Subject: AB/3/22/HH - Conversion of loft to habitable use including installation of 3 x dormers and roof terrace, addition of rendering, and alterations to fenestration/openings -Mews House, London Road, Arundel

With respect to the above planning application the **Arun District Conservation Area Advisory Panel** wish to make the following comments:

EAST ELEVATION PROPOSED

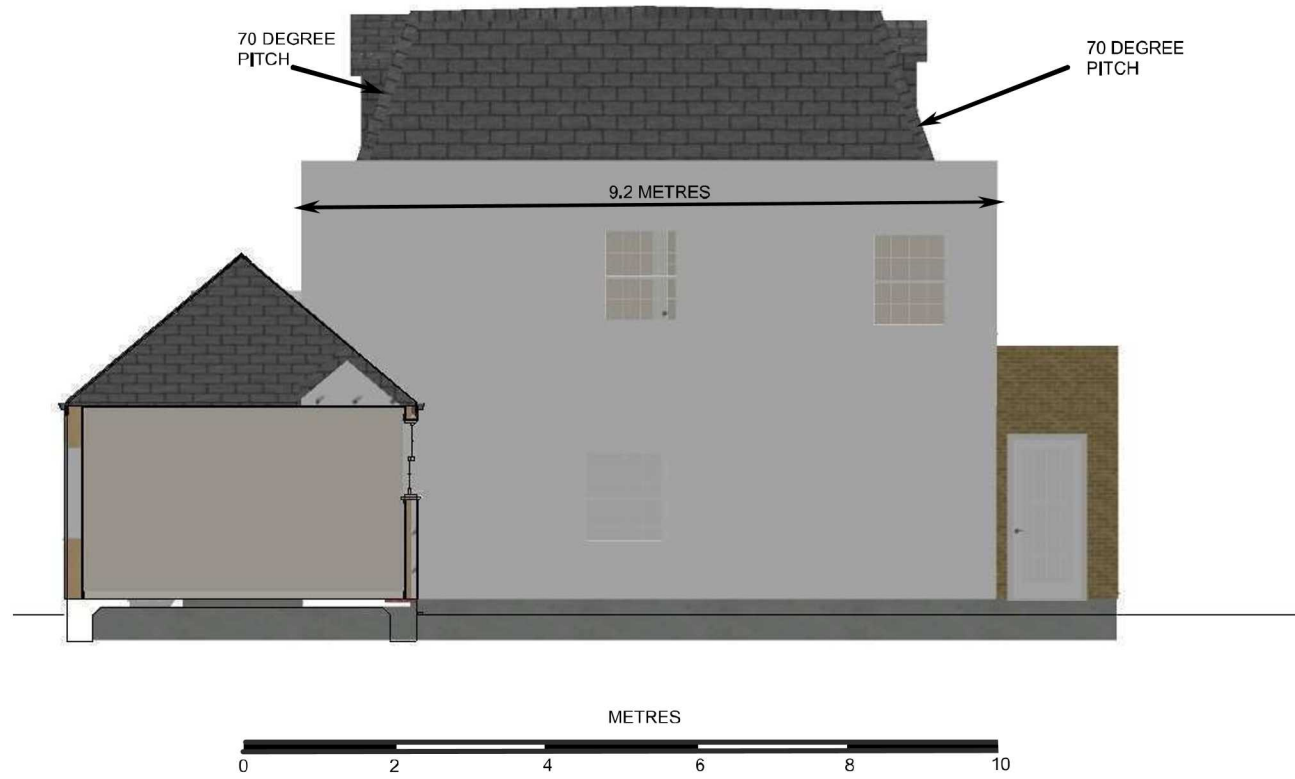
The intended new 'mansard' roof is not only oddly asymmetrical but simply does not suit the particular design of the property. In addition, the formation of a screened roof terrace next to it will exacerbate the incongruous nature of the proposals which will materially detract from the appearance of the building, the settings of the adjoining and nearby designated heritage assets and the character and appearance of the conservation area. The proposals will also alter the scale and nature of the building, detracting from its heritage significance as an historical ancillary, modest, and visually subservient structure to Tower House.
